LOT 1 WOODMEN HILLS FILING NO 7H

A PROPOSED OFFICE BUILDING FOR

FALCON FAMILY EYE CARE

Site Development Plan_V1.pdf Markup Summary

TRASH ENCLOSURE PLAN

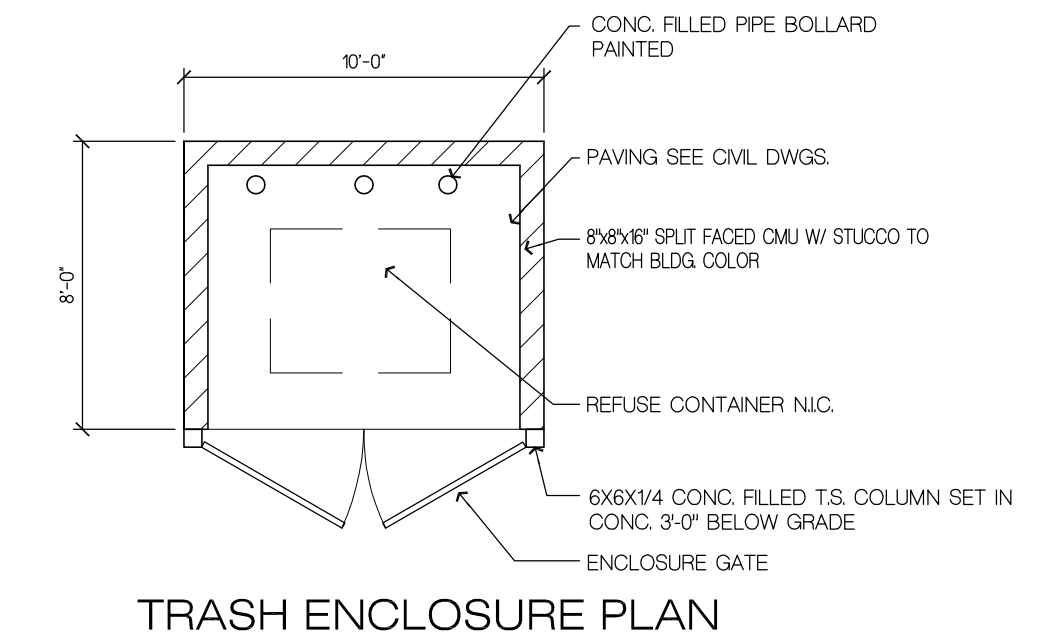
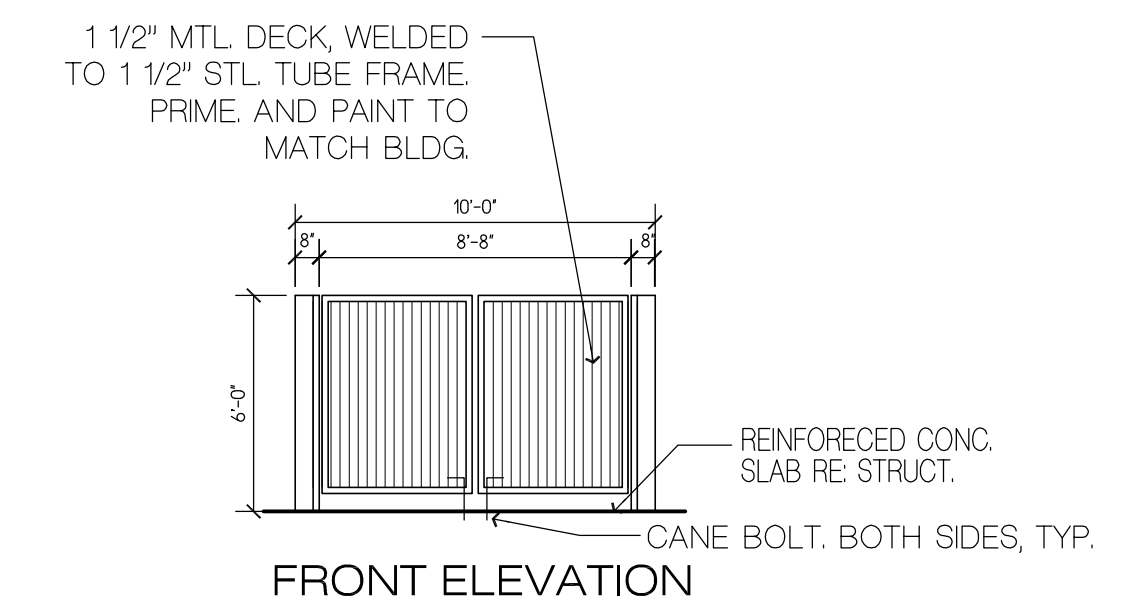
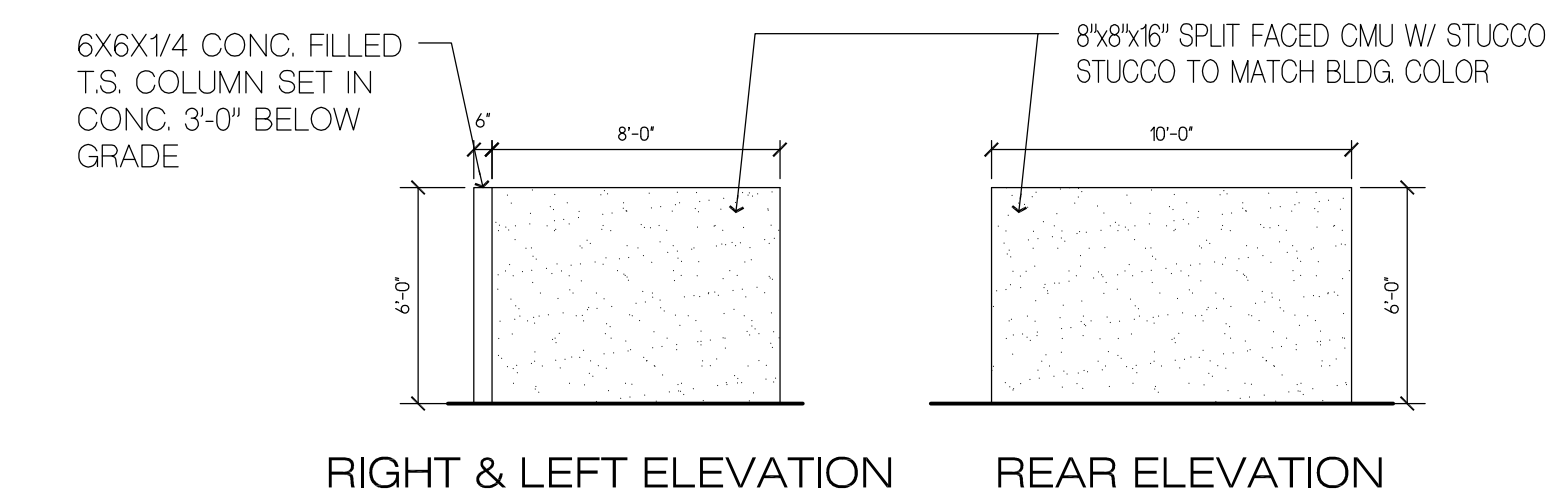
Please show trash enclosure detail. Please ensure trash enclosure meets enclosure screening standards in LDC Ch 6.
